# **WAIVER REQUEST**

## ***Monument Junction West Filing No. 1***

Waiver from Town of Monument Roadway Design and Technical Criteria:  
Appendix A, Table 5.2 Curb Return Radii

CURB NOTE:
ALL CURB TO BE CONSTRUCTED FOR THIS PROJECT SHALL BE TYPE 1.

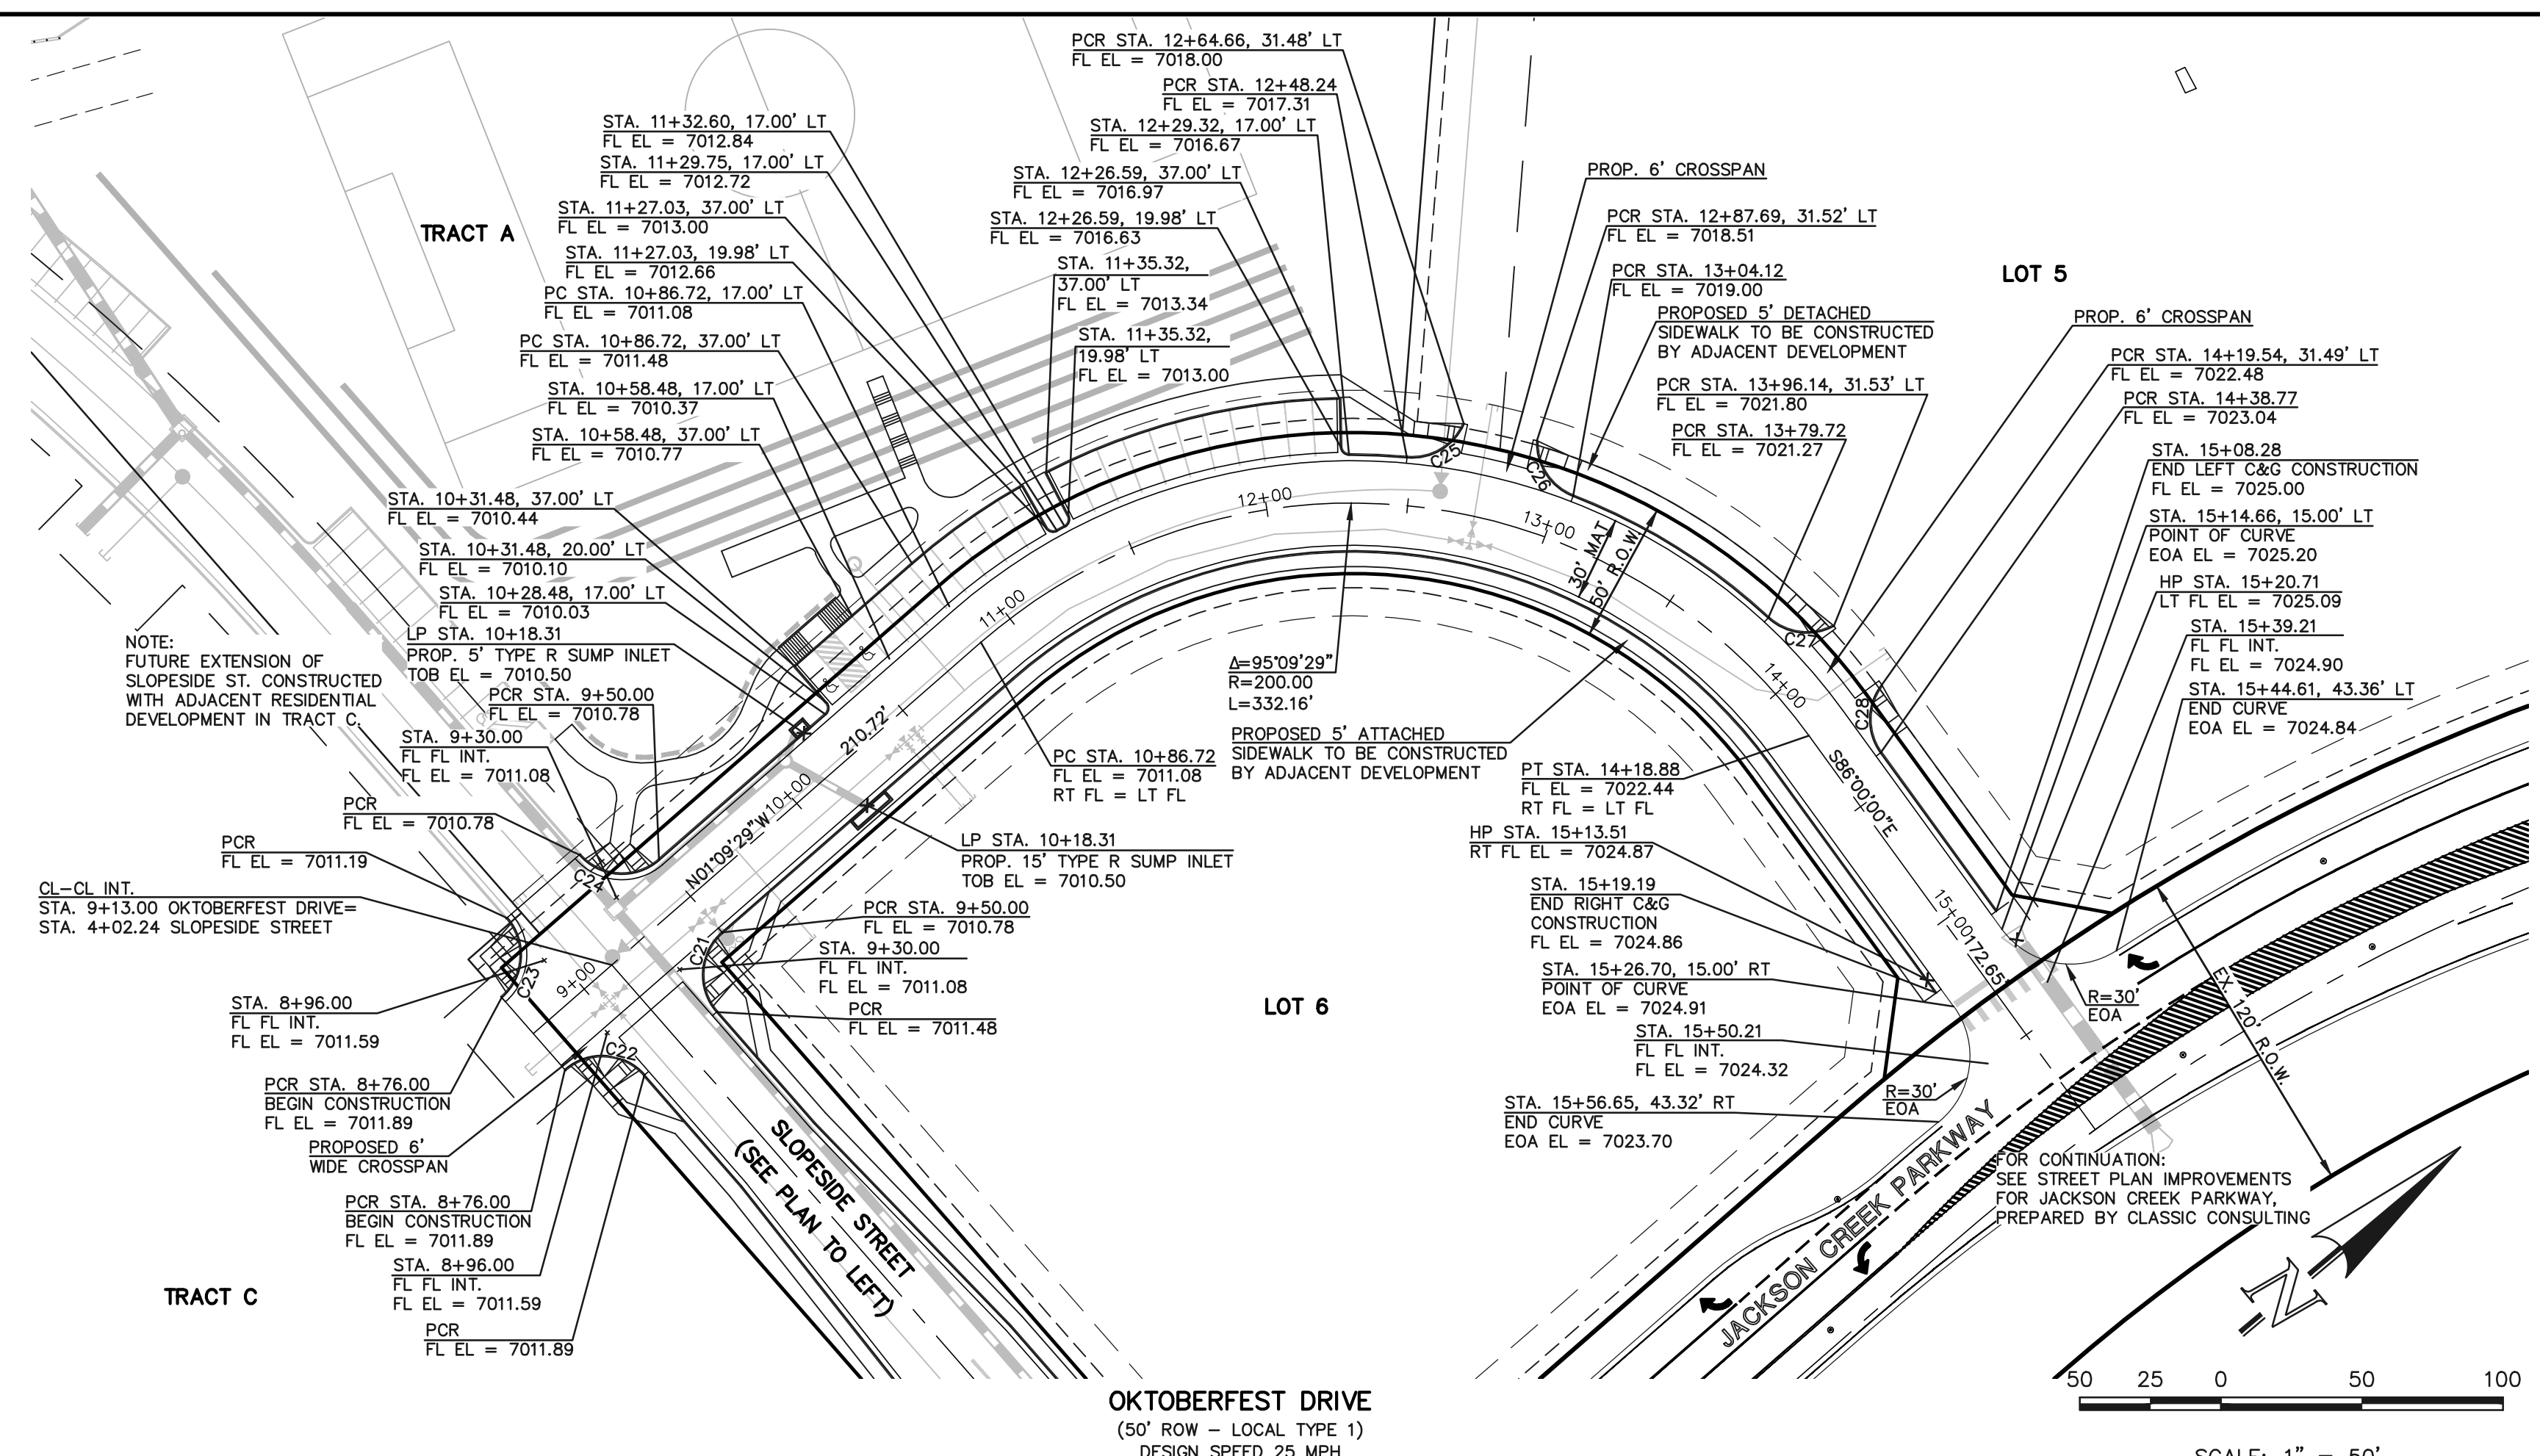
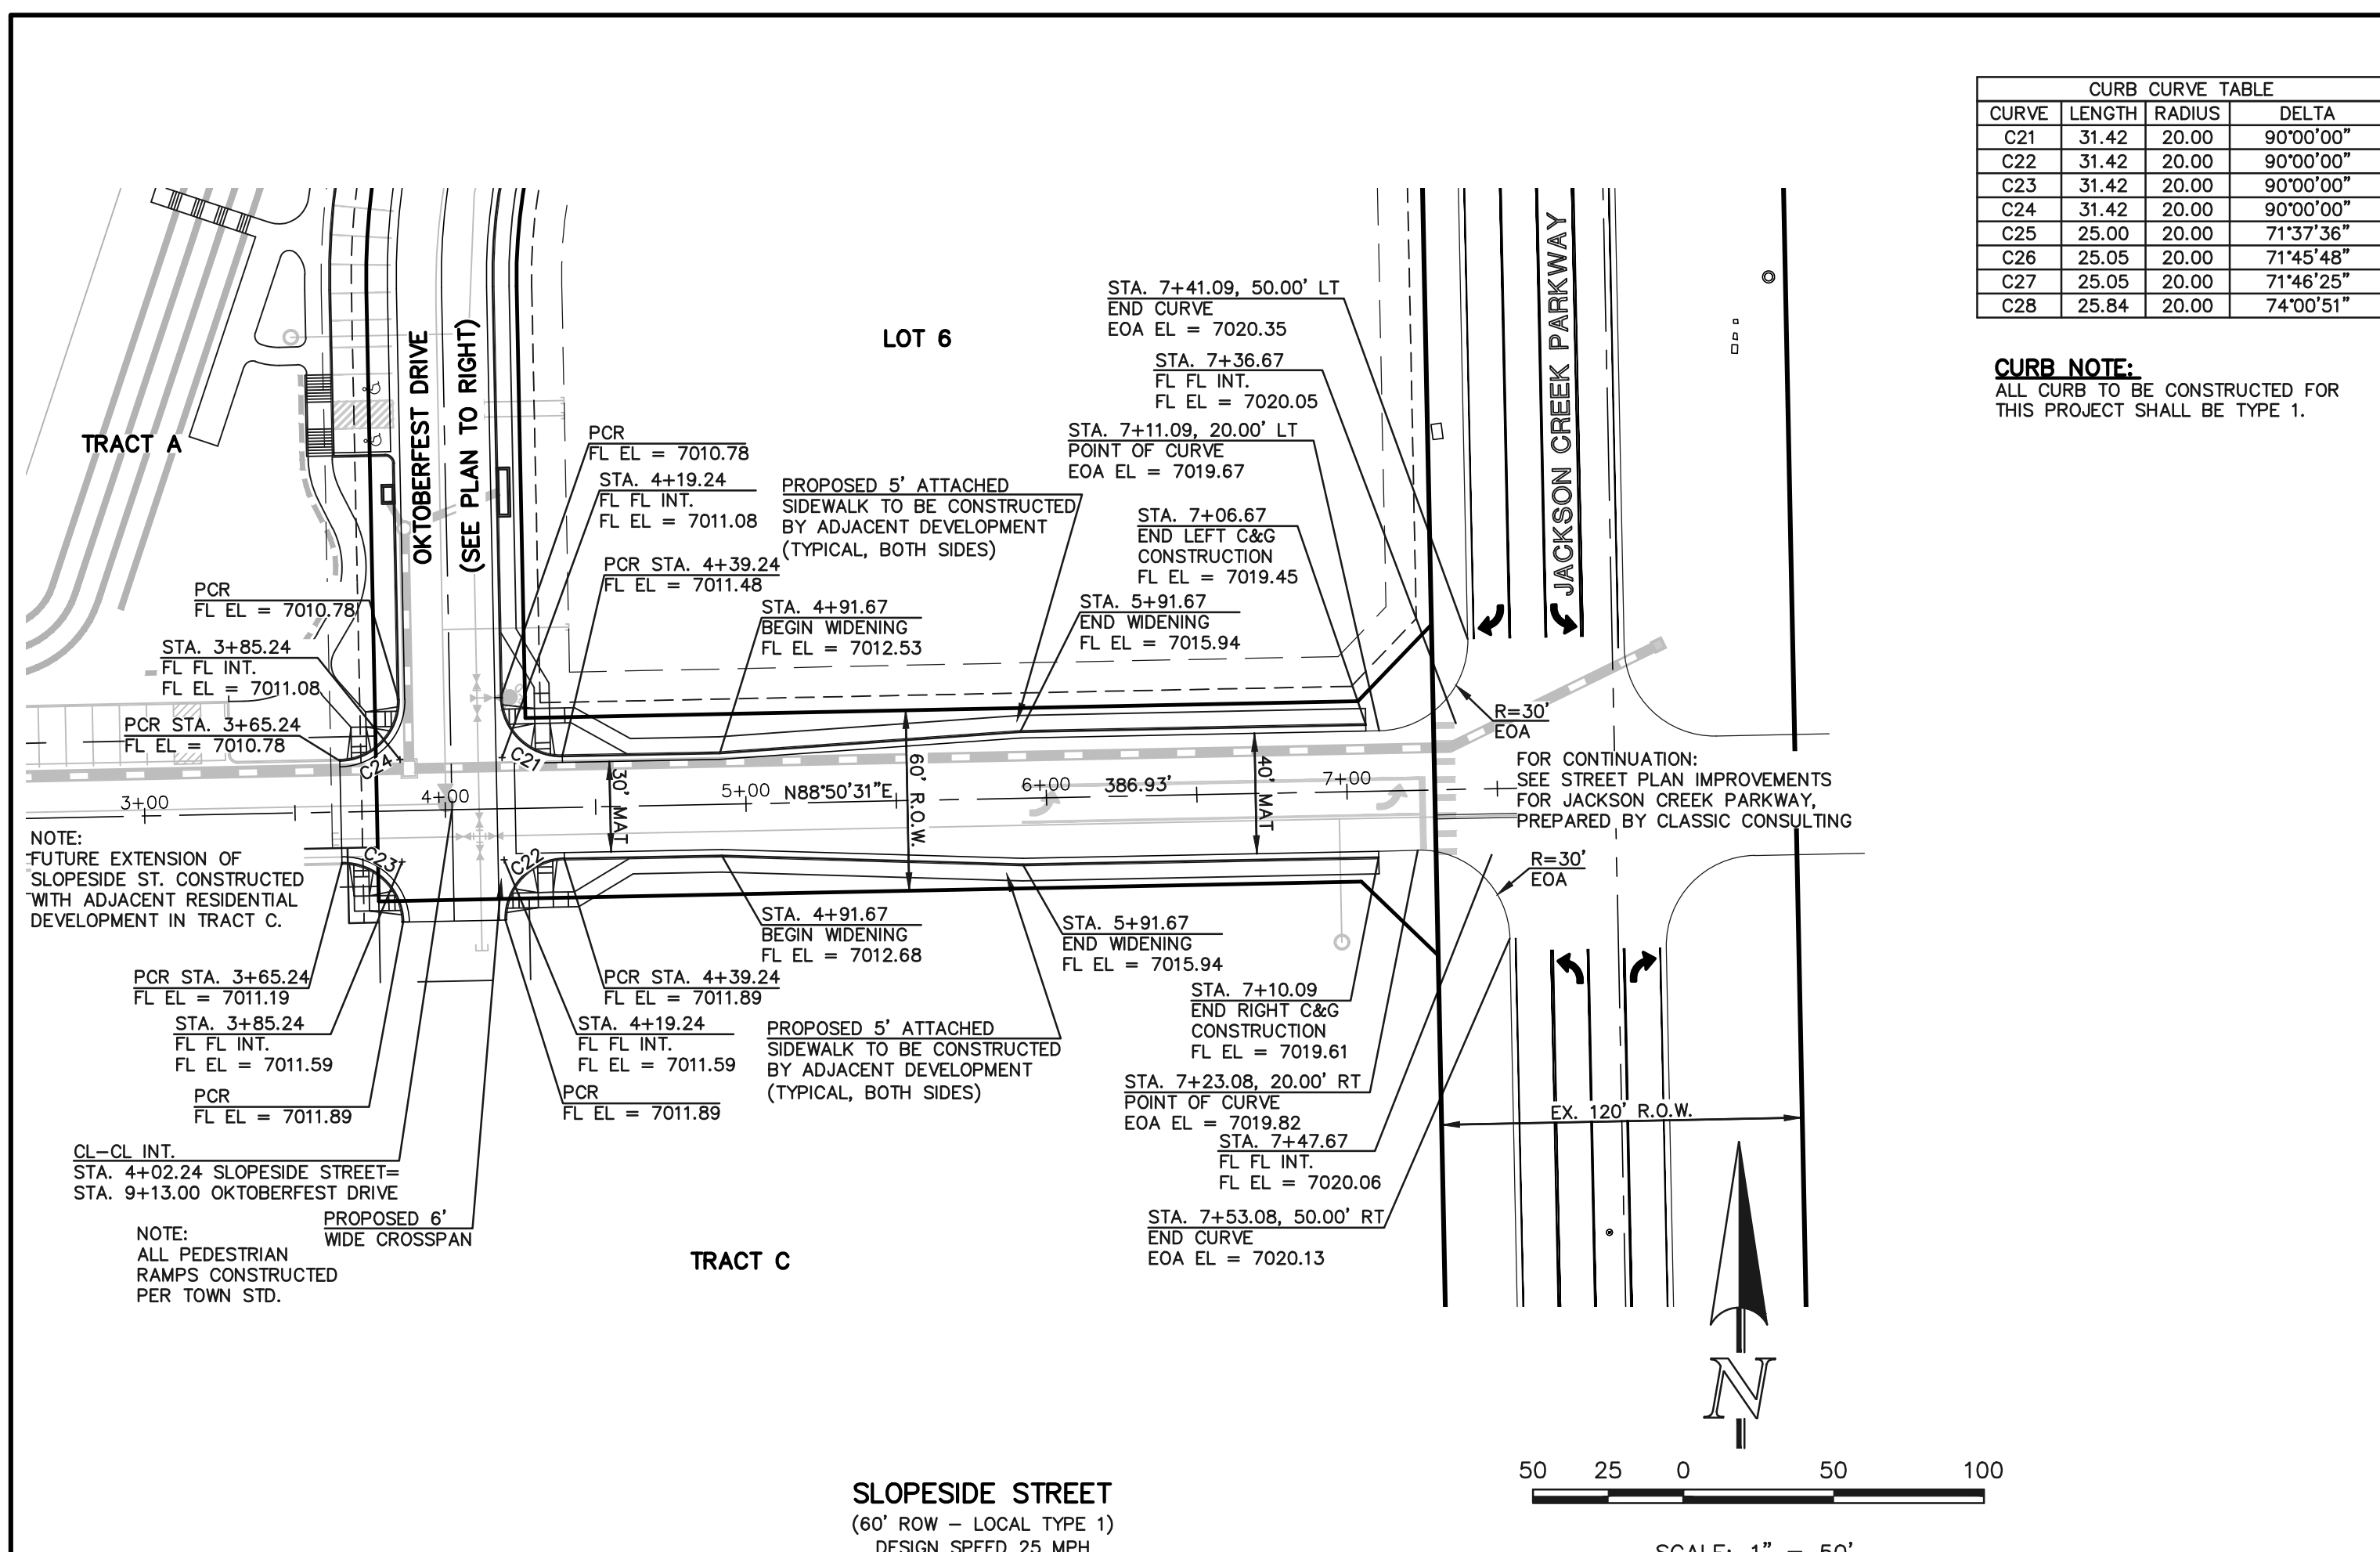
Criteria requires 30' curb return radii for Local roads intersecting Local roads  
Public street plans propose 20' curb return radii for Local - Local intersections

City of Colorado Springs criteria: 15' curb return radii for local roads

El Paso County criteria: 20 curb return radii for local roads

Appropriate Fire and truck access still provided
